OFFICIAL NOTICE OF DECISION

CITY OF ALBUQUERQUE  
PLANNING DEPARTMENT  
DEVELOPMENT REVIEW BOARD

**Project# 1005278**

HUNT & DAVIS, PC agents for JTH WEST, LLC and the CITY OF ALBUQUERQUE request the referenced/ above actions for TRACT A, **JUAN TABO HILLS WEST** and TRACT 1-A-1, Block 7, **JUAN TABO HILLS UNIT 2**, zoned R-D and SU-1/ MAJOR PUBLIC OPEN SPACE, located on the west side of JUAN TABO BLVD SE between the TIJERAS ARROYO and POCONO RD SE, containing approximately 98.47 acres. (M-21)

TITLE: **JUAN TABO HILLS ESTATES GRADING & DRAINAGE PLAN**

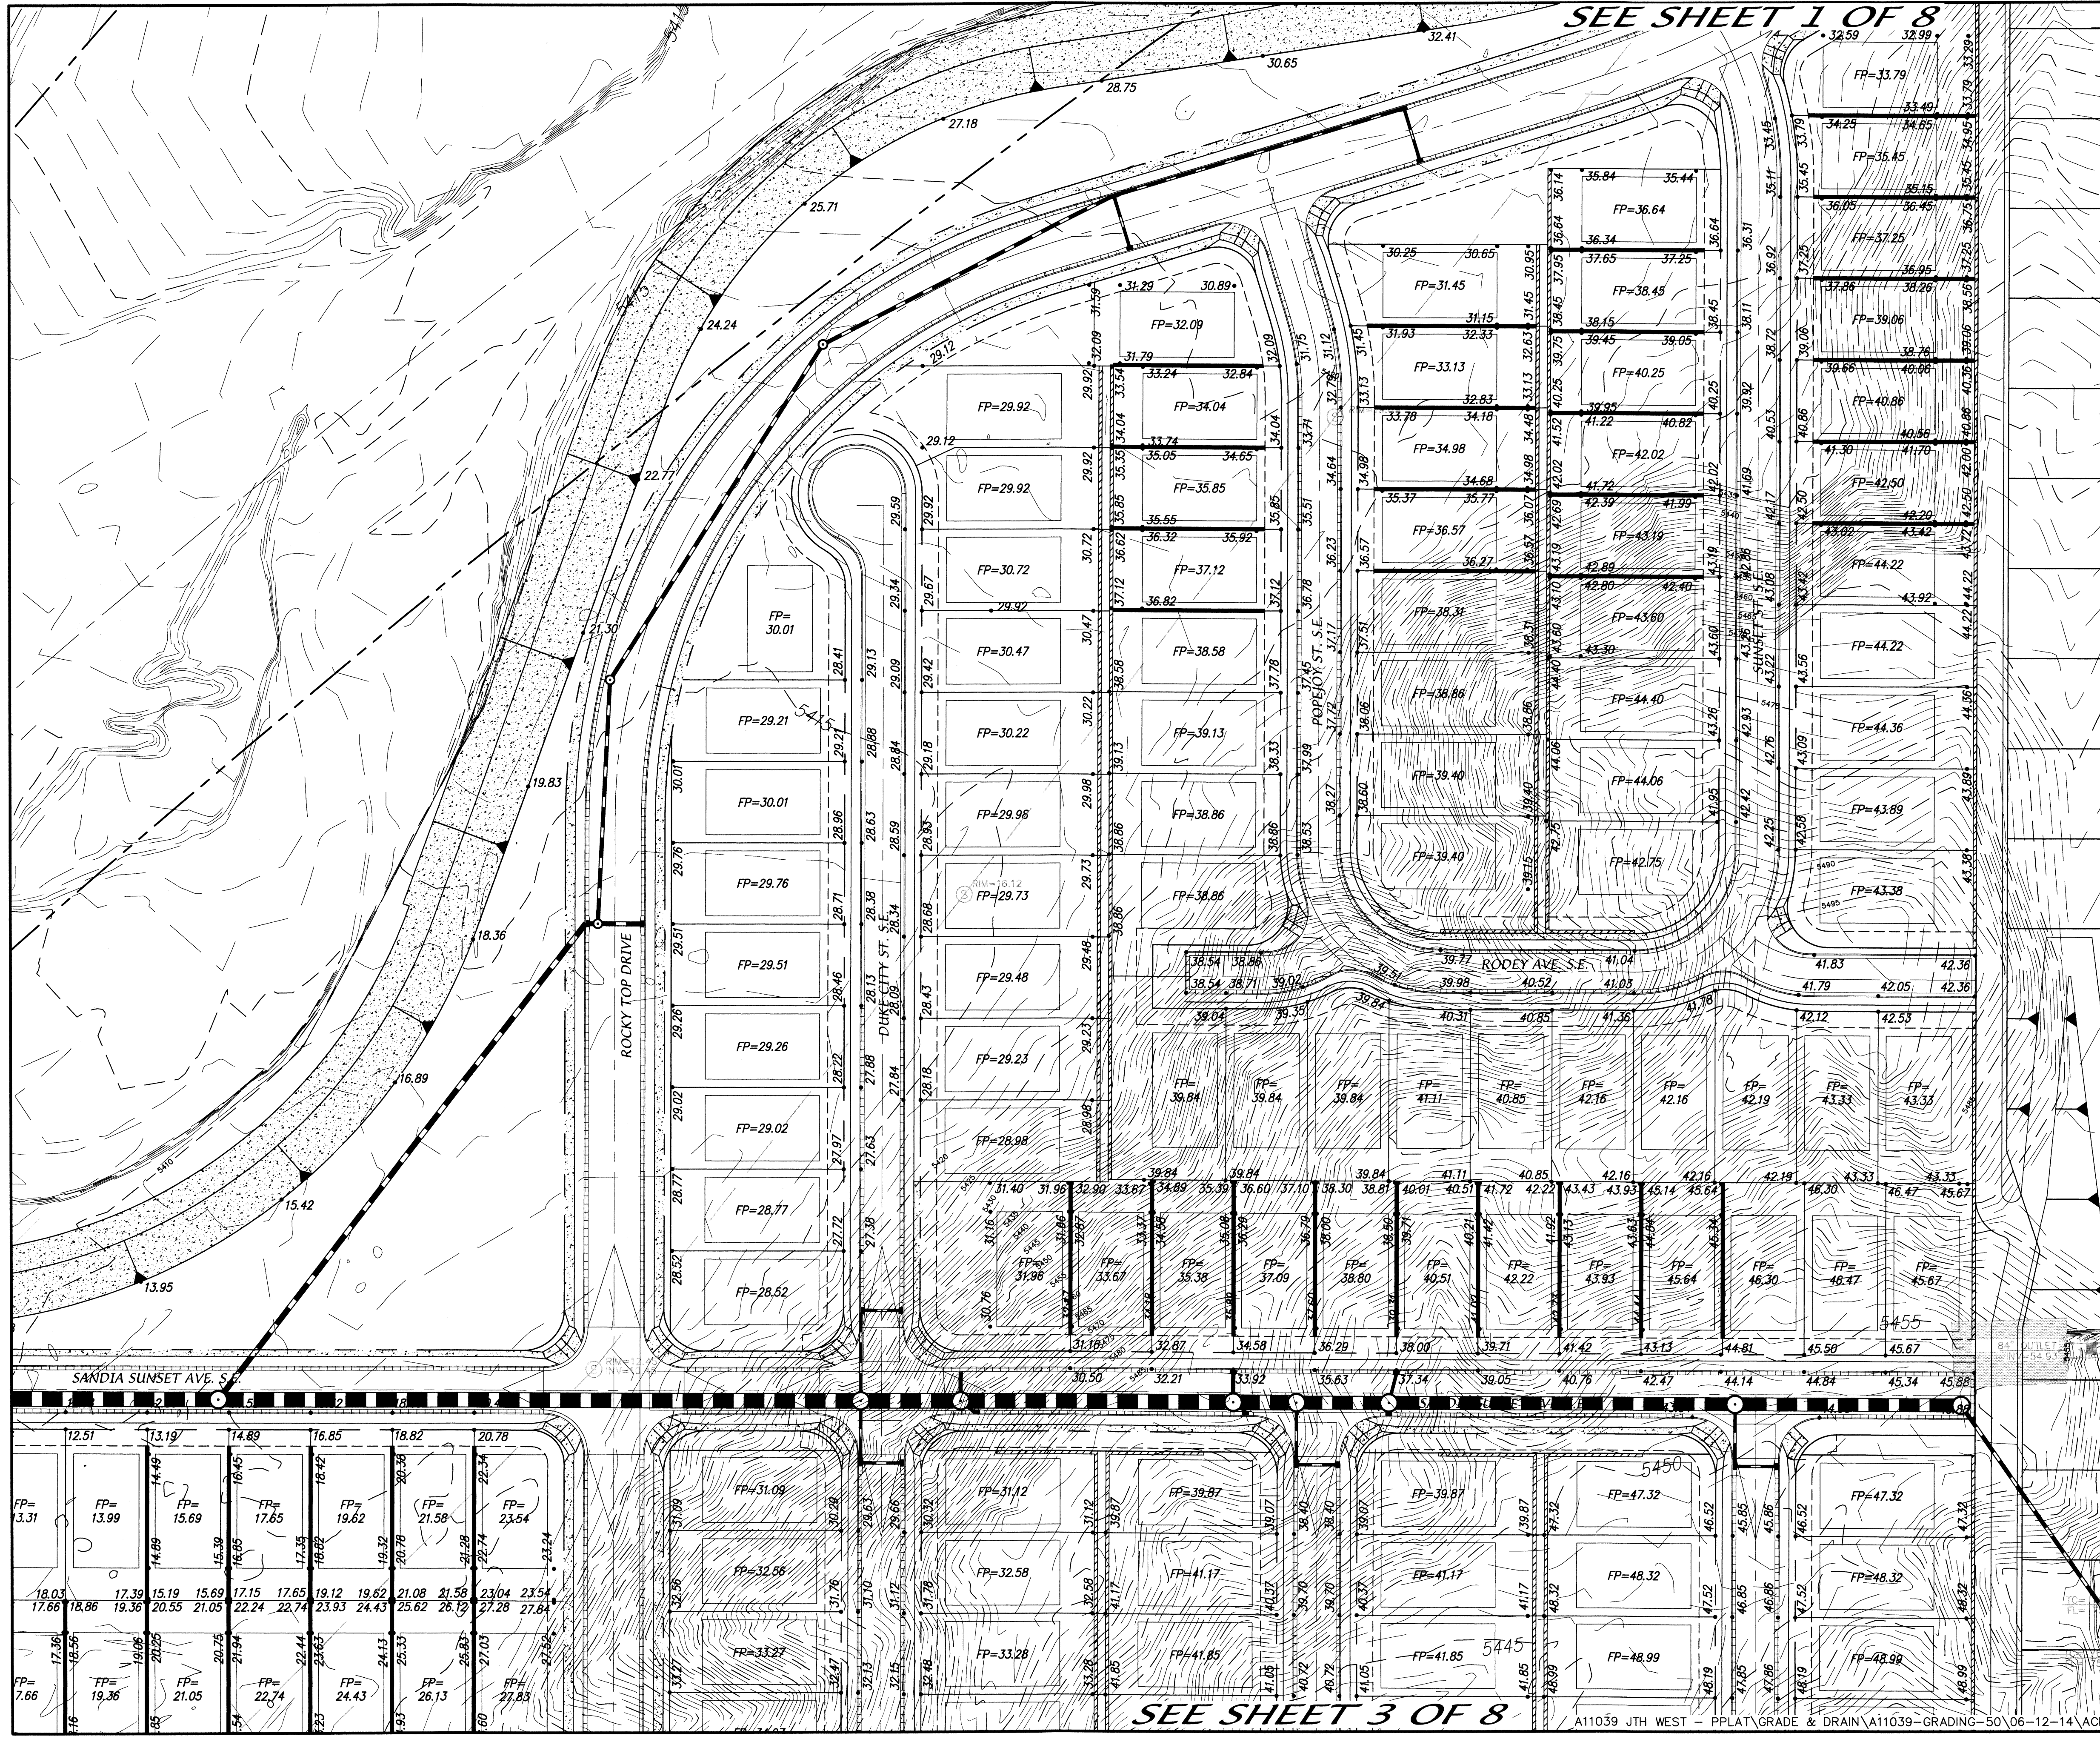
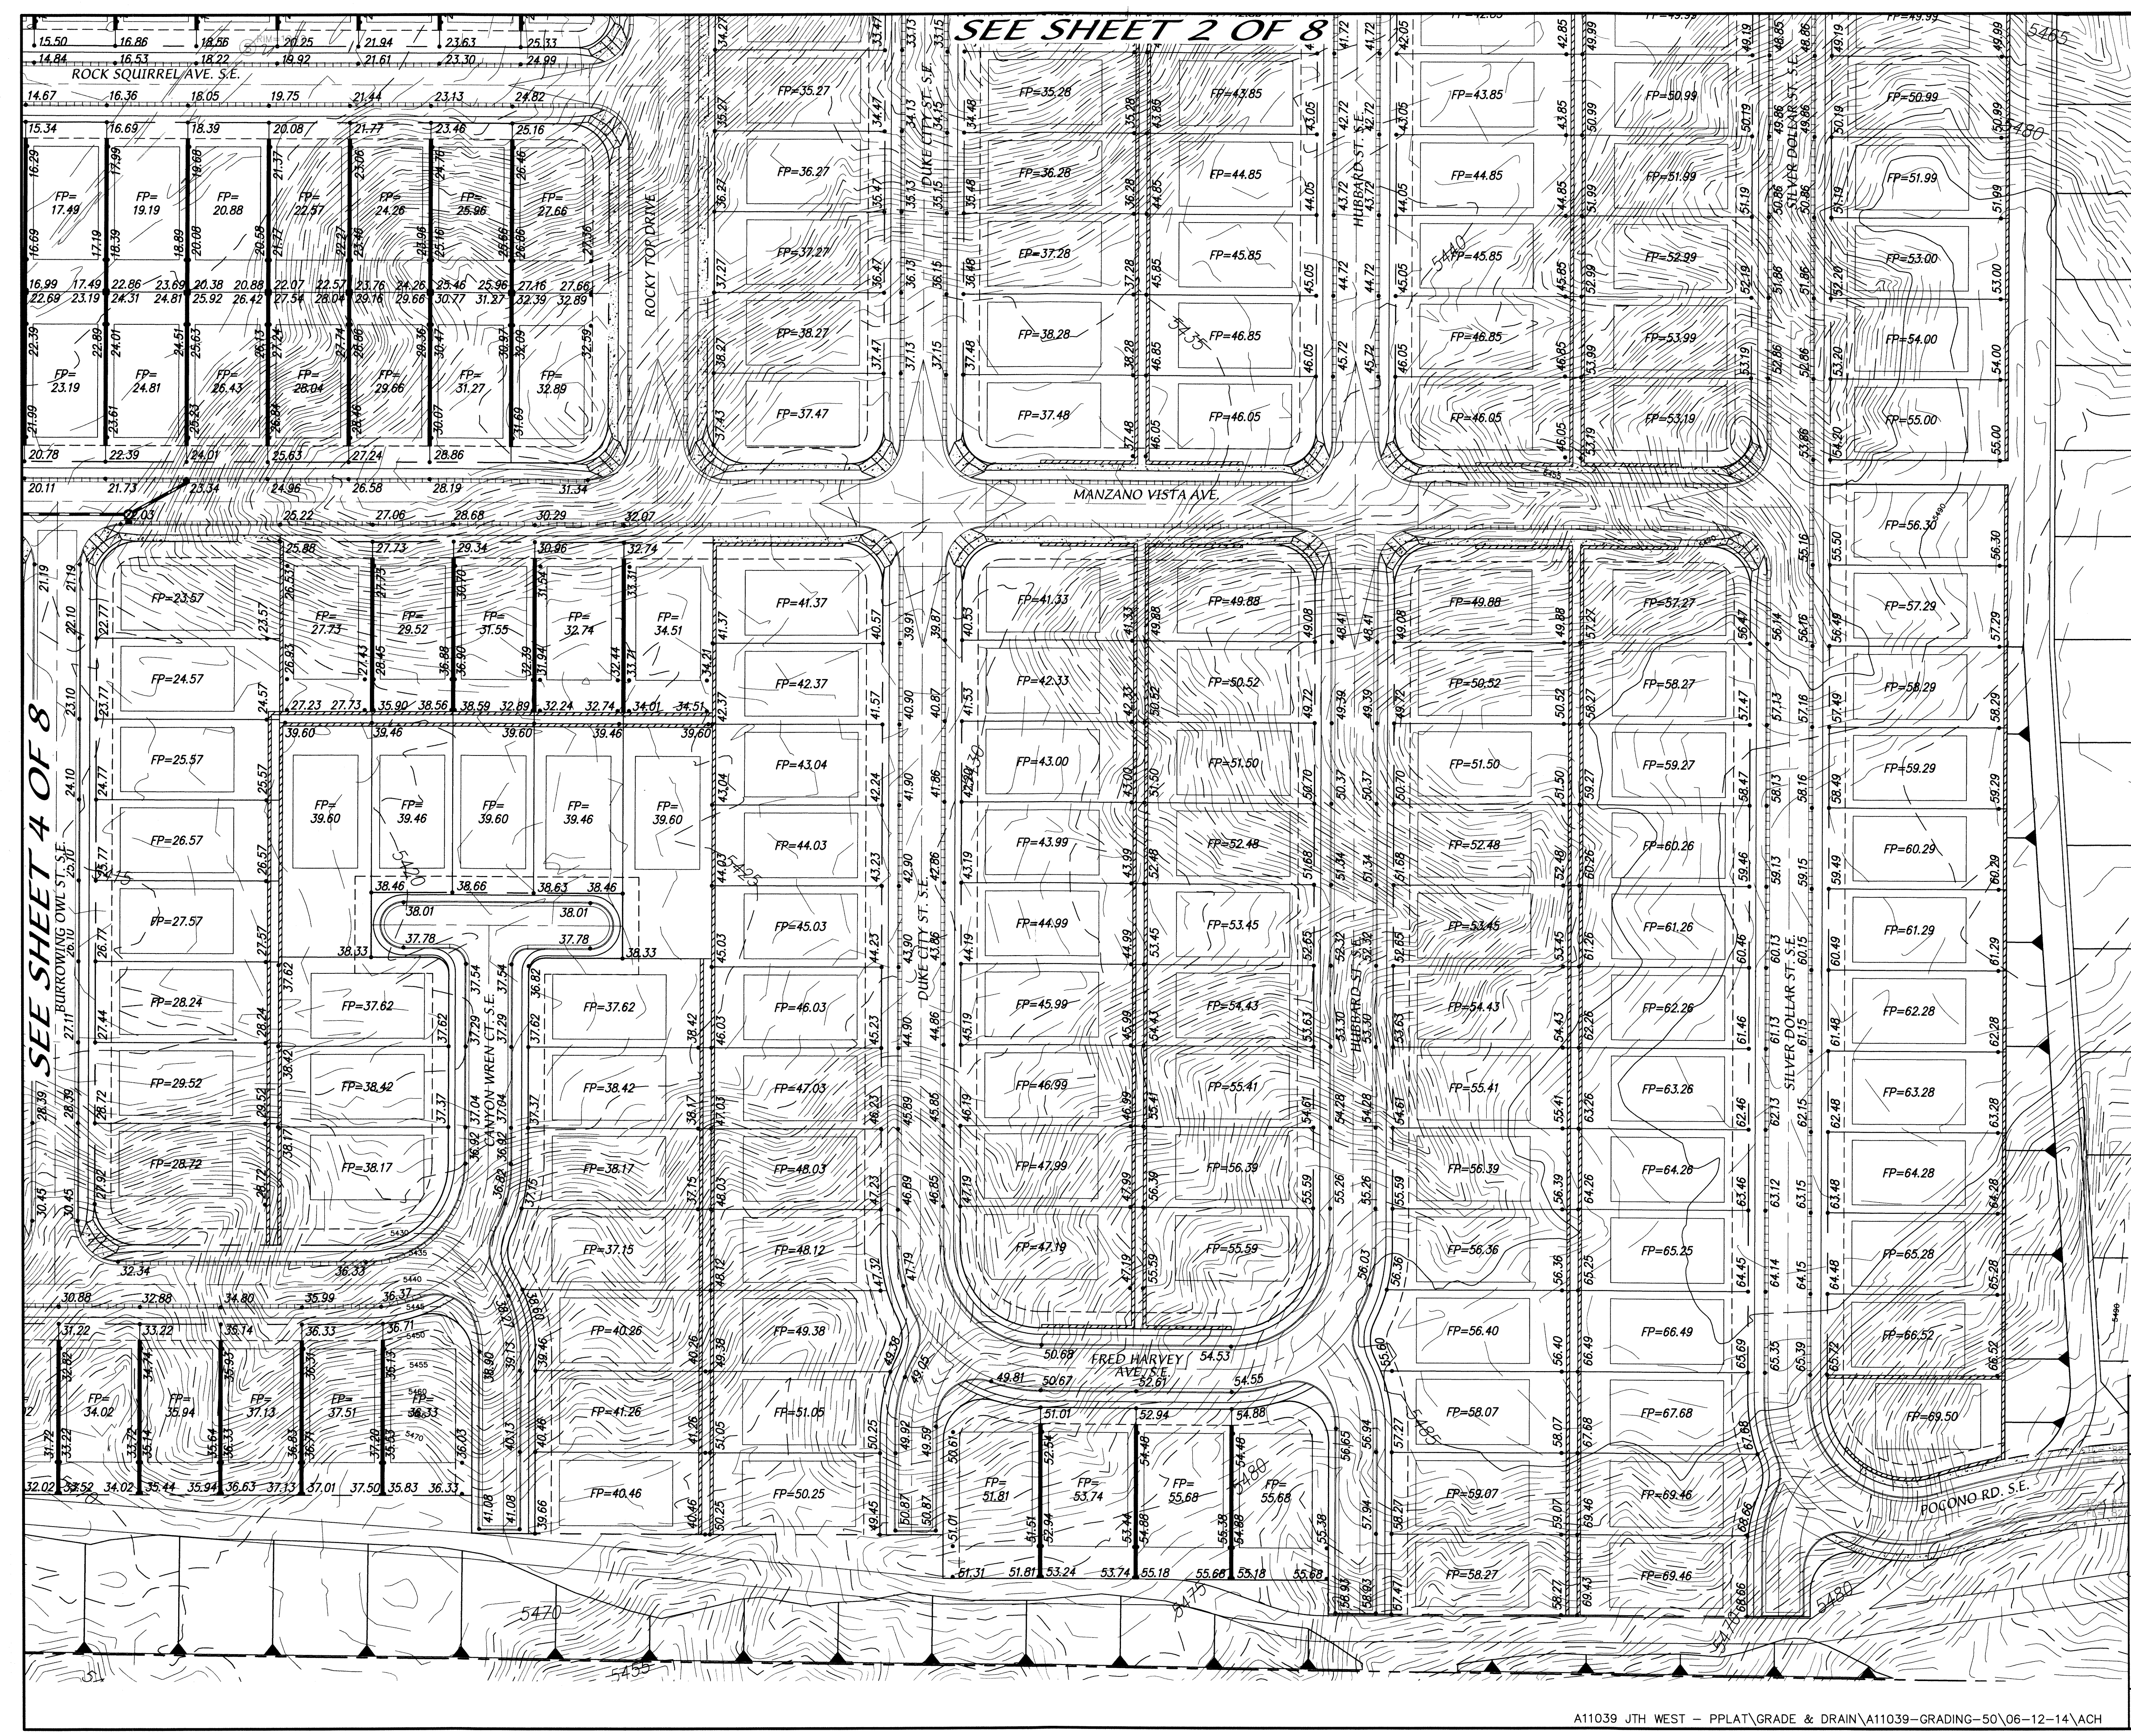
b. Proposed grading plan shows all lots to be below 5480' (within Pressure Zone 4ER).
